Re: Public Comment - File No. 2207-019
6950 SE Maker Street/Parcel No. 9350900620

We own and live at the residence located at 7155 SE Maker Street, across SE Maker Street from the referenced project ("Project") proposed for 6950 SE Maker Street ("Site"). The Site is owned by The Strand Trust ("Strand"). Our home is on the south side of SE Maker Street and slightly east (uphill) of Project.

MERCER RESIDENCE
6950 SE MAKER ST MERCER ISLAND, WA

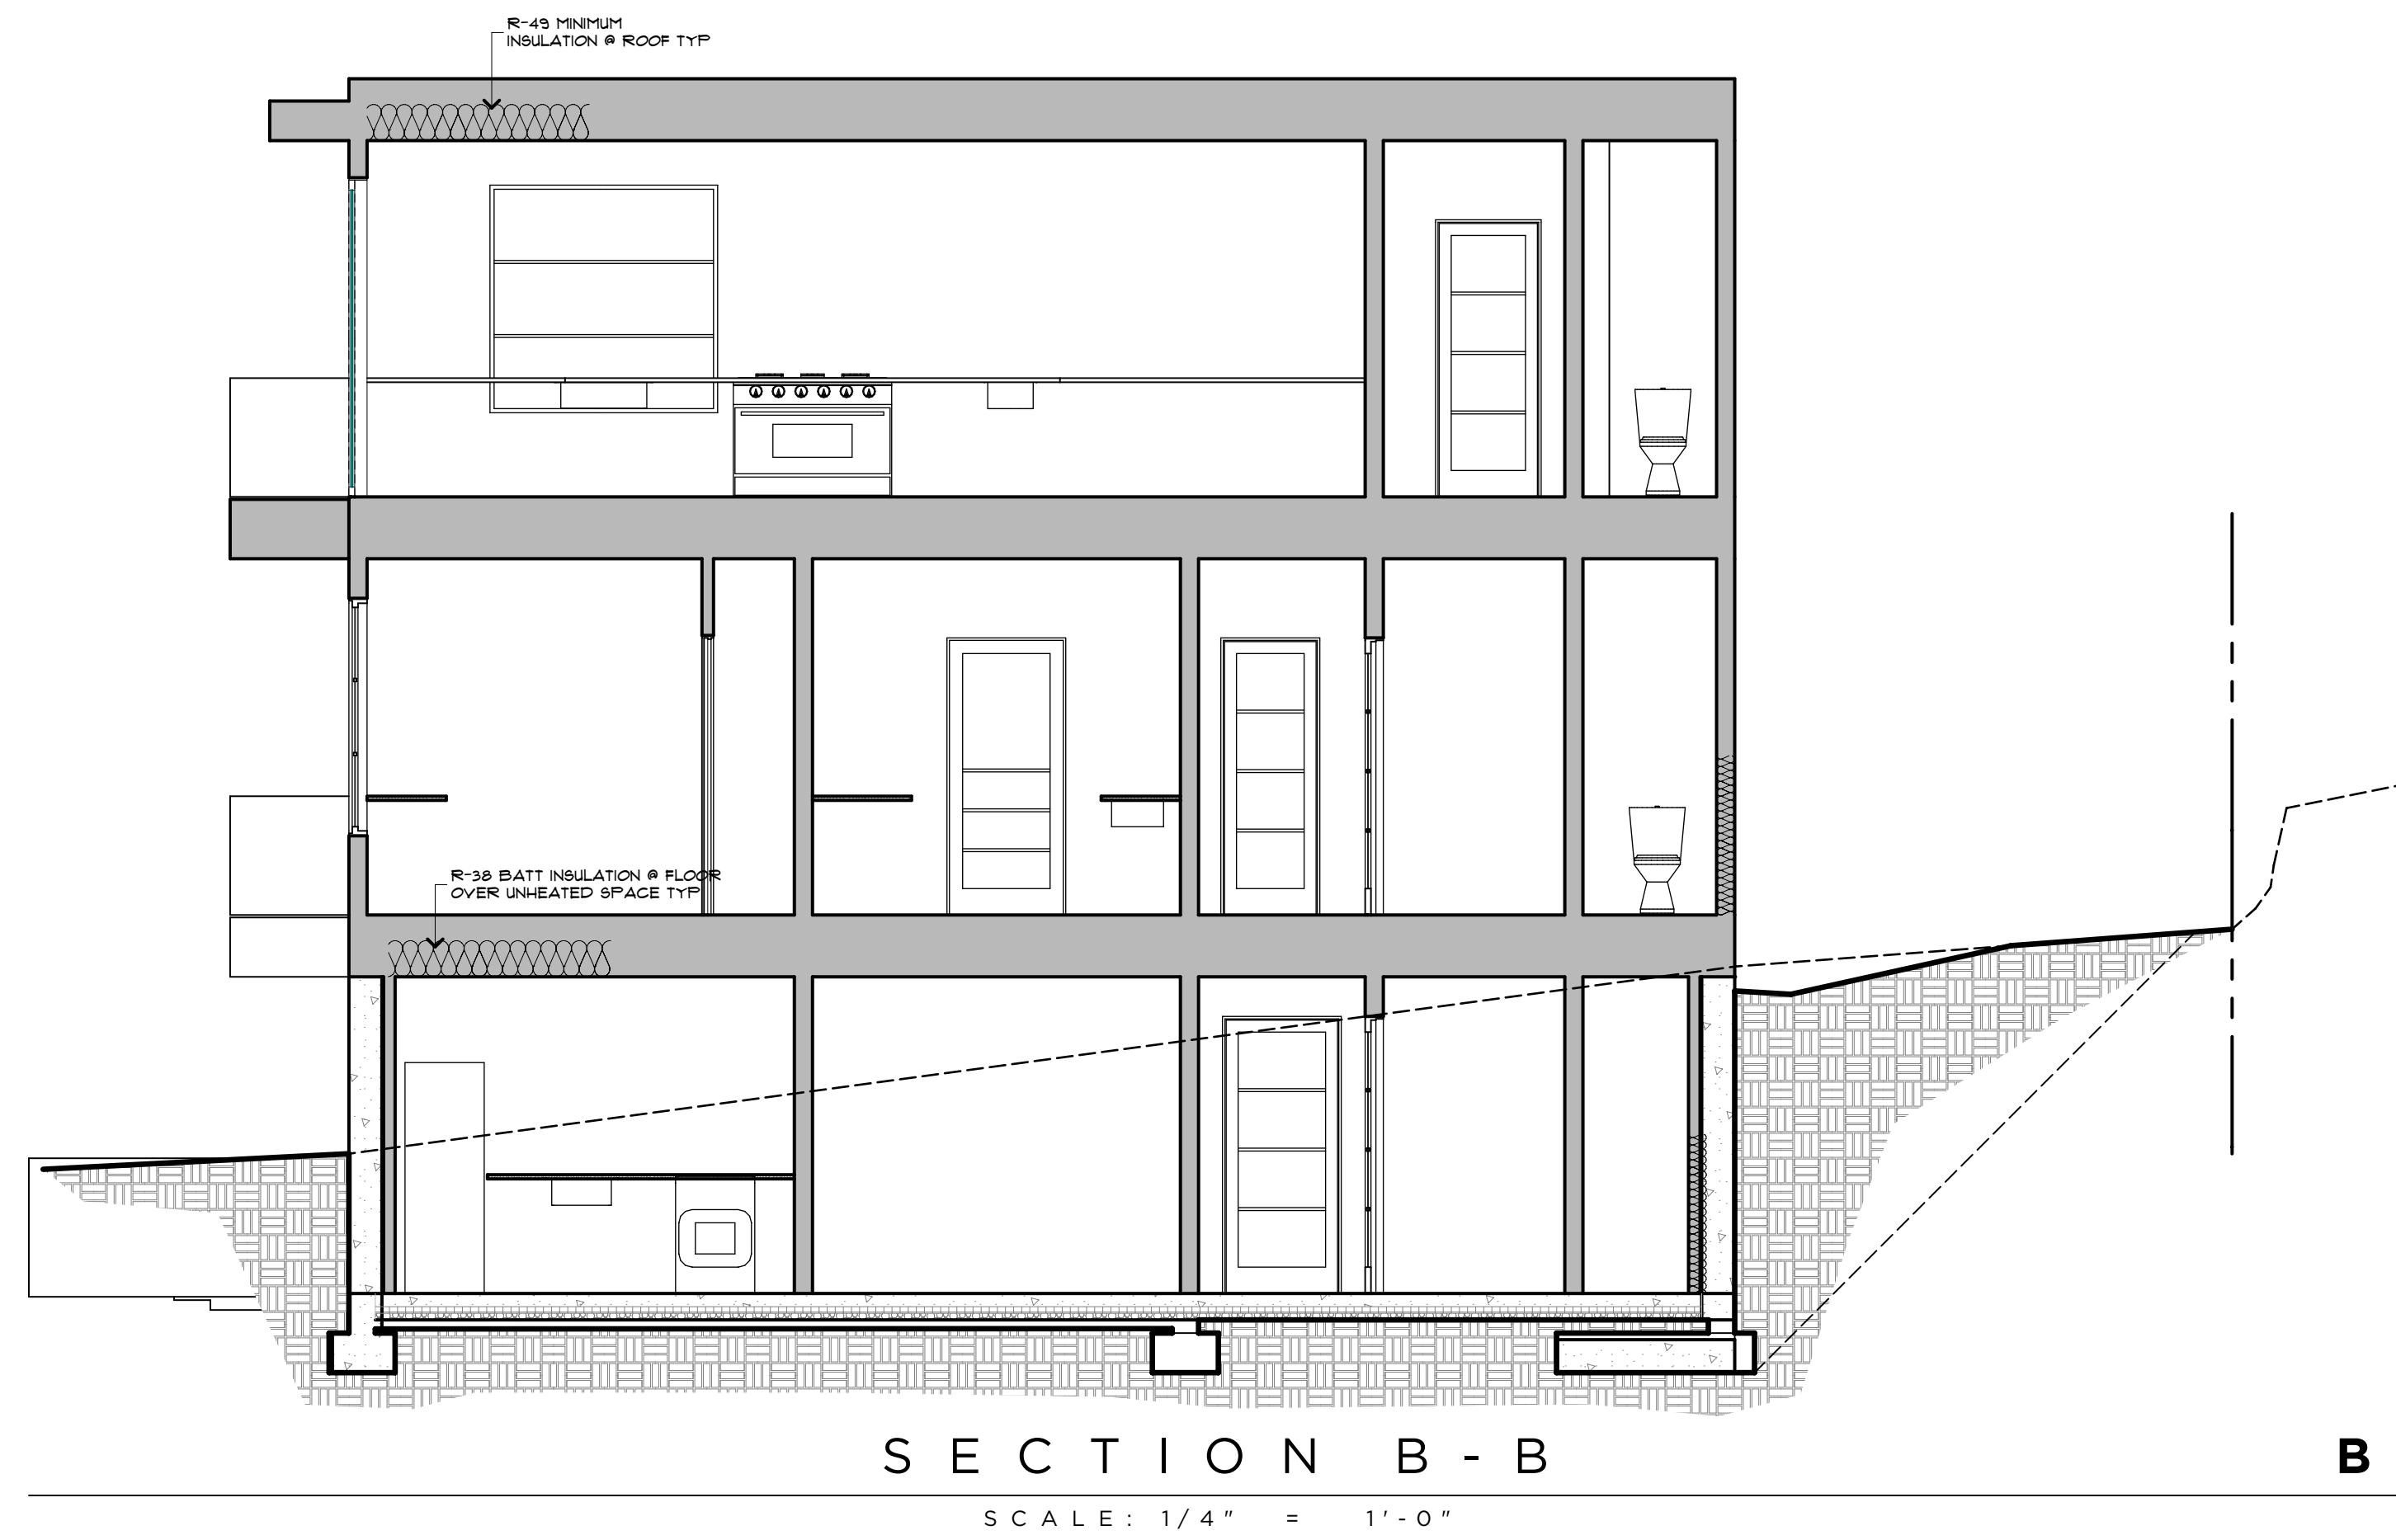
A. In particular, we share the concerns that the Project does not properly calculate the Existing Grade of the Site, as defined in MICC 19.16, in determining the permitted height for the Project. This results in a proposed residence that would be substantially taller than permitted by the MICC and would loom high above the rest of the homes in the neighborhood. We are also concerned that the rockery retaining walls that support a substantial amount of fill

Notwithstanding the substantial amount of fill located on the Site, the Proposal does not appear to use the Site's "Existing Grade," as defined by MICC19.16.010, to determine the permitted height of the proposed residence at the Site. Use of the appropriate Existing Grade, i.e., the grade prior to bringing a substantial amount of fill to the Site, would reduce the permitted height of the proposed residence by several feet, creating a structure less out of scale to the neighborhood and in compliance with the MICC.
